Application for a non-material amendment following a grant of planning permission.
Town and Country Planning Act 1990

Non-material amendment following the grant of
BN/23/15/PL for stretcher course of brickwork
along verges & corbelling detail at junction of
high & lower.

Demolition of existing 2 storey detached house & construction of a pair of semi-detached replacement dwellings with flood preventative measures.

Status: Preliminary	Drawing: Proposed Elevations 02	Project: 4 Lake Lane
Scale: 1:100 @ A3	Dwg No: 052-D-06 - REV 1	Address: 4 Lake Lane, Barnham, West Sussex
NOTE: This drawing is to be scaled for planning purposes only	Date: 02.09.2015	Client: Joanne Lee and Bill Hislop

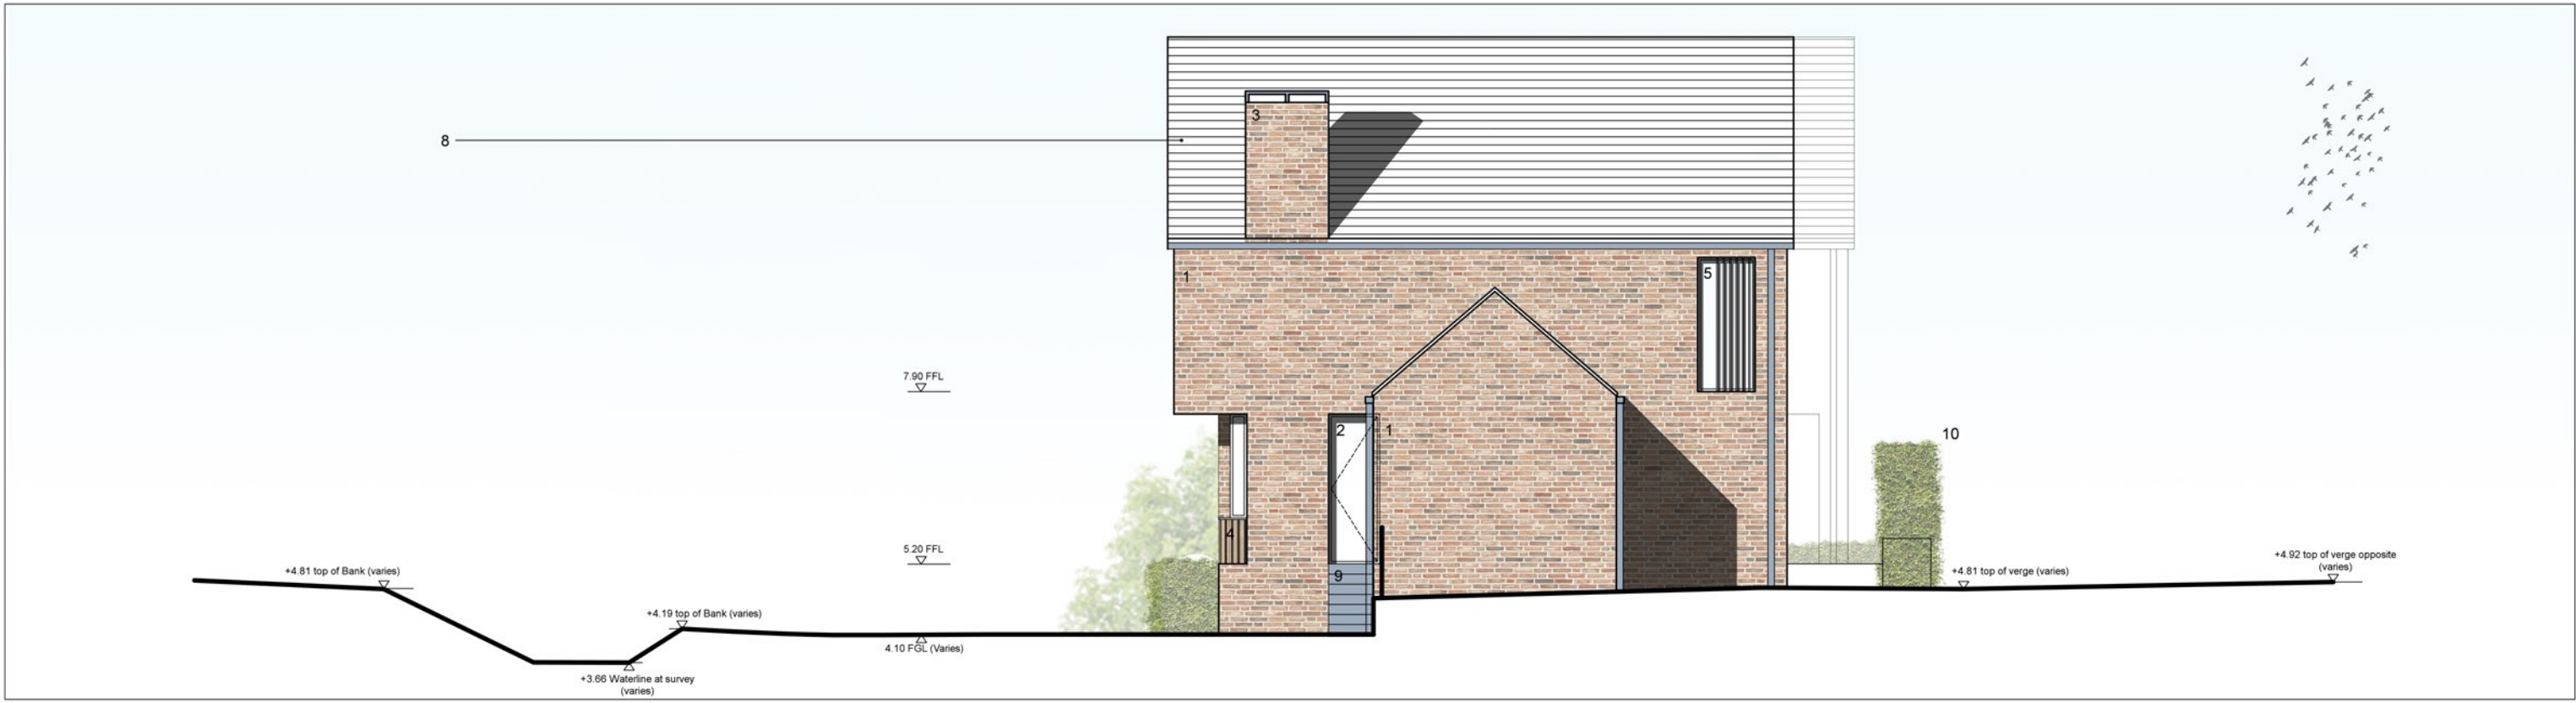
1. Stretcher course of brickwork along verges
2. Corbelling detail at junction of verge and eaves.

The plans show a 'flush' verge. In order to have a clean look to the verge the stretcher course will enable the undercloak to rest in a linear fashion on the brickwork. The brick corbel will enable the fascia and soffit to have a termination point.
